State Significant Development Application - SSD 6092 Response to Submissions

Block 8, Central Park

Mixed Use Development

May 2014 ■ 13381

VENTILATION

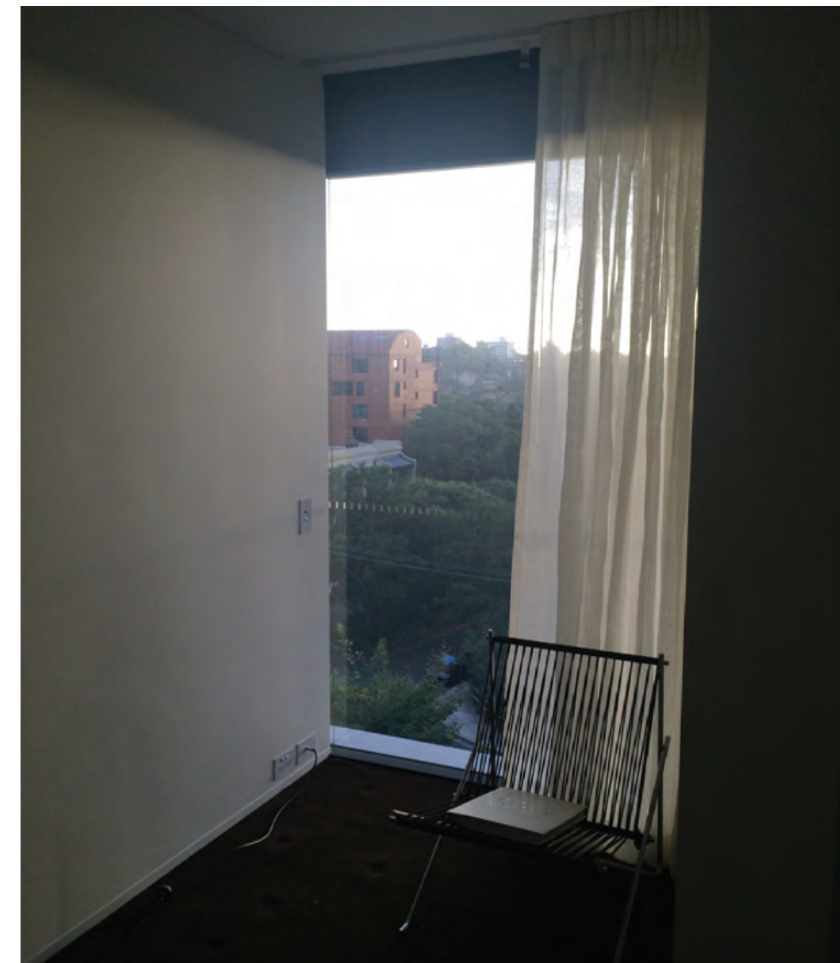
DP&I requested consideration be given to the number of apartments identified as being provided with cross ventilation, and the reliance of the slots to provide access to cross ventilation. Modelling is to be provided demonstrating how ventilation adequately travels through apartments across different levels (i.e. on Levels 3 – 7 and Level 9). Details of how bedrooms that outlook into the slots are provided with natural ventilation is to be provided, and justification in relation to the width of the slots and the provision of windows is also to be provided.

All apartments within Block 8 are naturally ventilated while 75.8% are cross ventilated, as shown in **Figure 1** below. This percentage exceeds the Residential Flat Design Code (RFDC) 'Rules of Thumb' which specifies that 60% of apartments should be cross ventilated.

Cross ventilation is achieved by way of the light and ventilation slots in the façade, which are either accessed by each apartment and/or external terraces, loggias and balconies. In addition, lobbies on all typical levels are now provided with awning windows at both the northern and southern ends, allowing these spaces to be naturally ventilated, supplemented with assisted mechanical ventilation. (Levels 9 – 11 are ventilated at the southern end only, and there are no windows to the level 12 lobby, however this is considered appropriate given the size of the lobby and the fact that it provides access to only two apartments).

The articulation of the façade, with slots, rebates and privacy fins, will significantly improve the natural ventilation potential through single and dual aspect apartments, due to the pressure differential generated on the various openings into the apartments.

It is noted that there are 44 apartments which because of their single aspect are not cross ventilated. However, all are provided with windows that open onto loggias, balconies and/or the external façade to ensure continuous air flow.

On the Abercrombie Street façade, natural ventilation transfer ducts are proposed from the facade into the body of the apartment, to act as a natural cross ventilation source when the loggia is closed.

TYPICAL FLOOR PLAN - LEVELS 3-8 1:200 @ A1

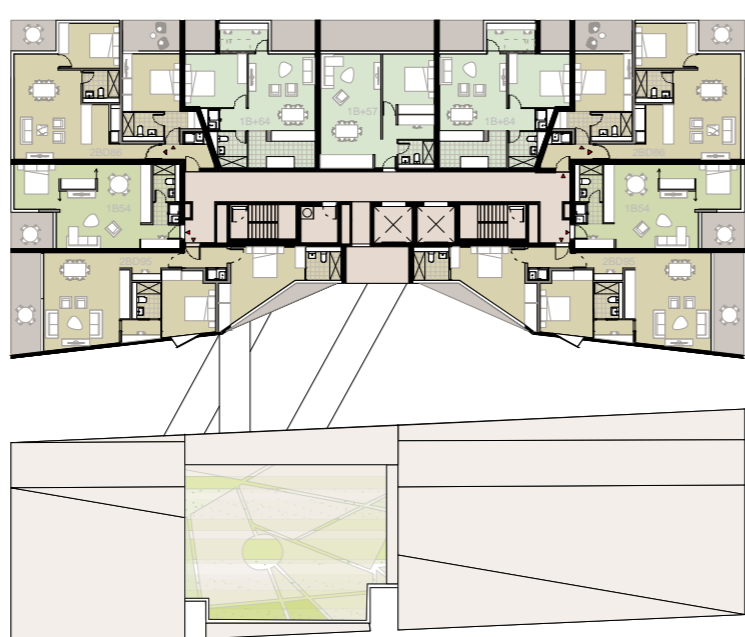
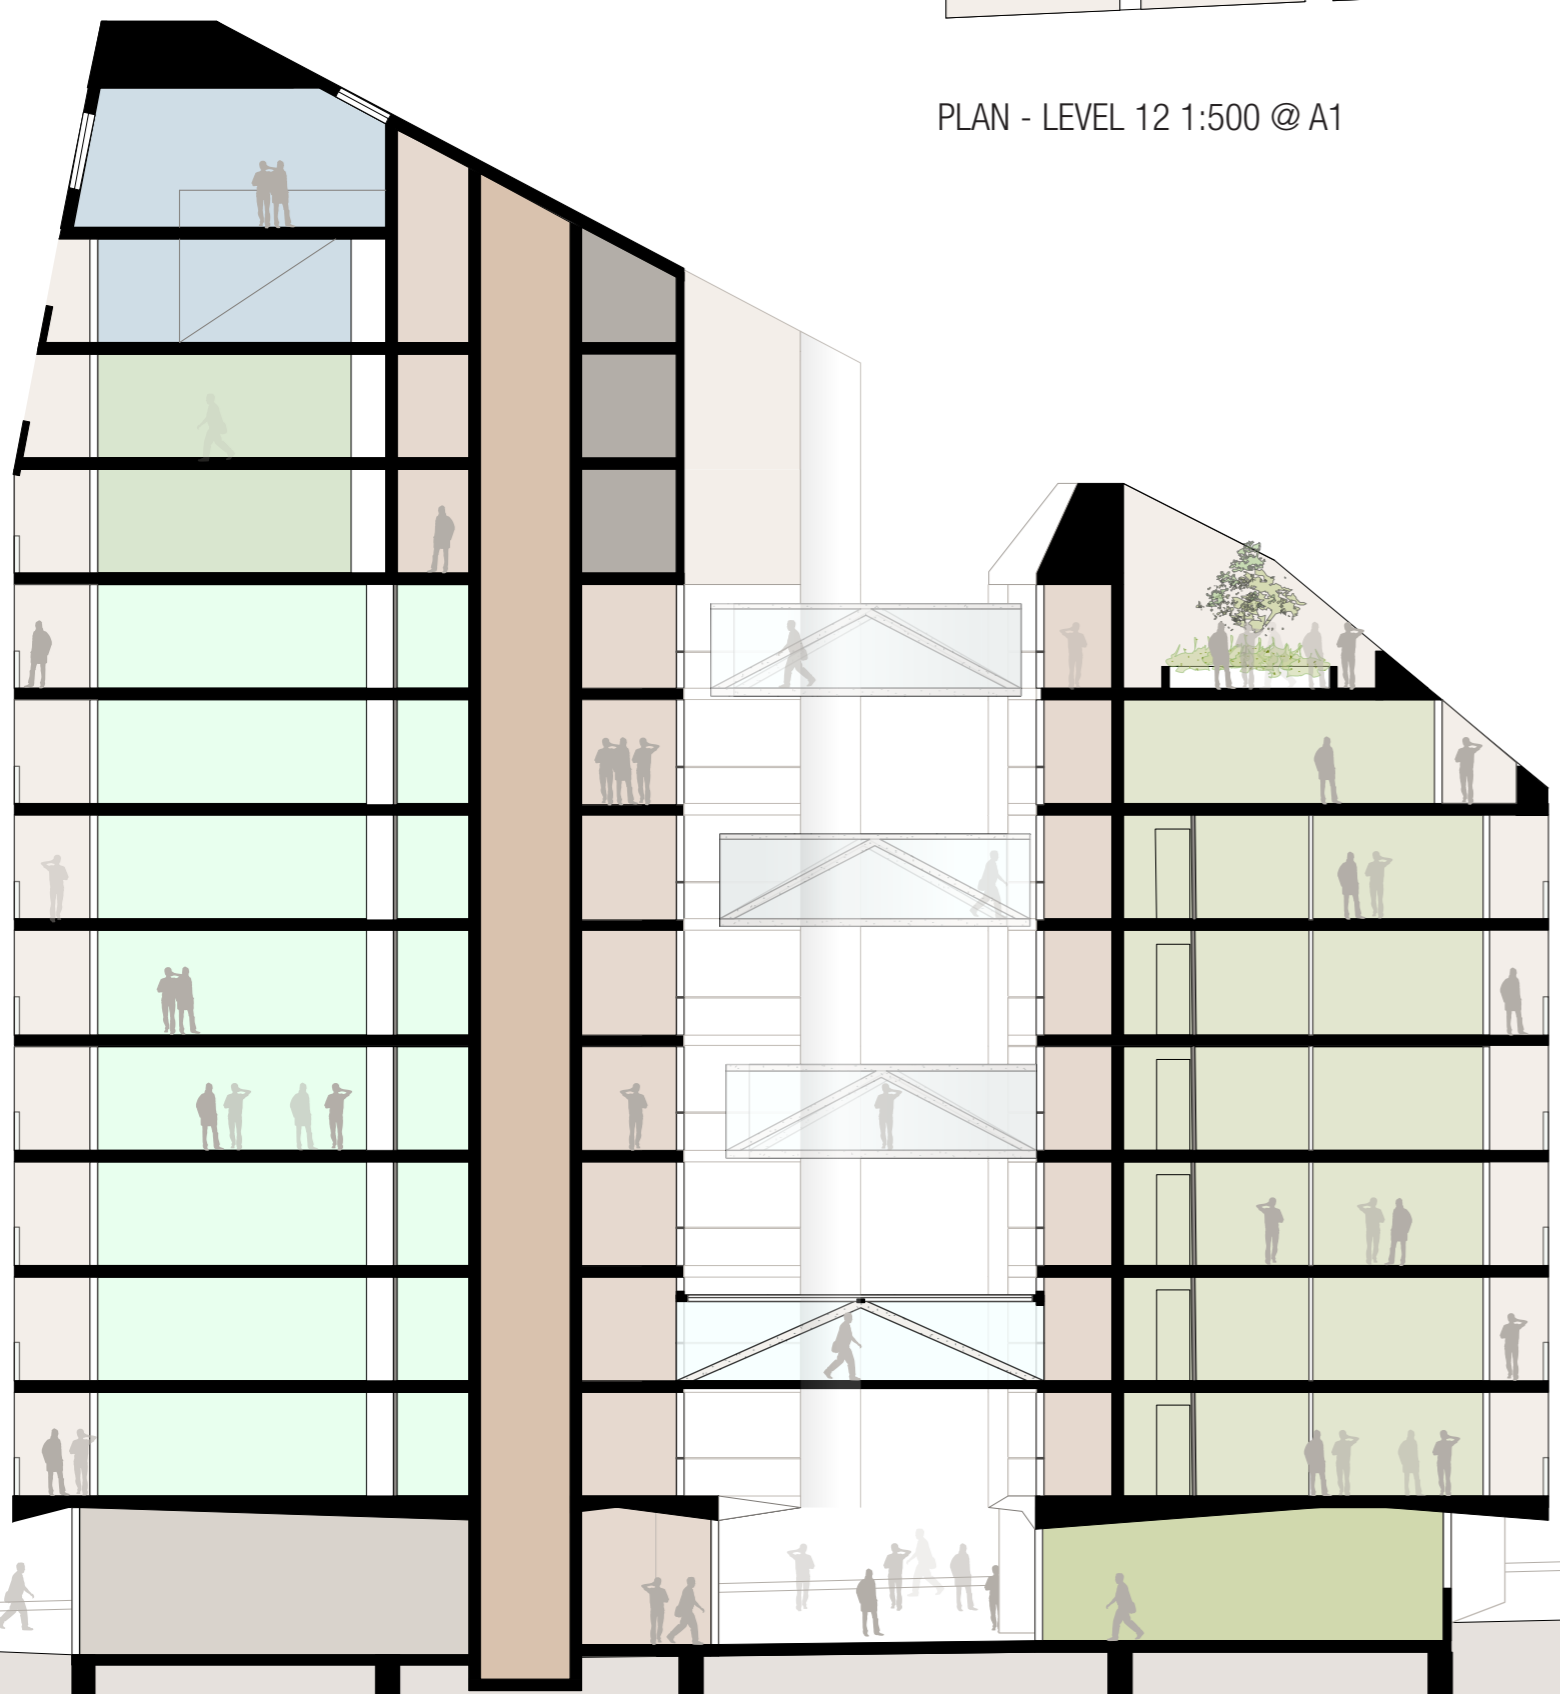
DP&I requested consideration be given to the number of single aspect units within the development, particularly those with an outlook toward the south. In particular, justification in relation to the number of these apartments is to be provided.

DP&I requested consideration be given to the 'Rules of Thumb' as contained in the Residential Flat Design Code. In particular, justification is to be provided in relation to apartment depths, depth to back of kitchens, access to cross ventilation and suitability of the proposed open space areas (including clarification of the design of loggias, and location of open space to apartments on the ground floor).

There are 44 apartments which are single aspect, 16 of which are south facing single aspect units. However, all are provided with amenity in the form of:

Instead, the effective depth of the single aspect apartments has been reduced on average to 10m, and south facing single aspect apartments have been reduced on average from 14.5m to 14m deep. The reduction improves amenity, particularly in relation to provision of light and ventilation to the rear of the apartments. This is also enhanced by the amended layout of these apartments where utilities including the bathroom and laundry are now located to the rear, affording bedroom and living spaces premium access to natural light, and generously sized bedrooms which now have additional area that can be used by the occupant as a walk-in-robe, attached study or additional storage.

In accordance with the RFDC 'Rules of Thumb' single aspect apartments should be no more than 8m from a window. While the single aspect apartments within Block 8 exceed this requirement, their depth has been reduced on average to 10m,

and south facing single aspect apartments have been reduced on average from 14.5m to 14m deep in consideration of the amenity of occupants. The apartment layouts have also been amended to deliver additional amenity including:
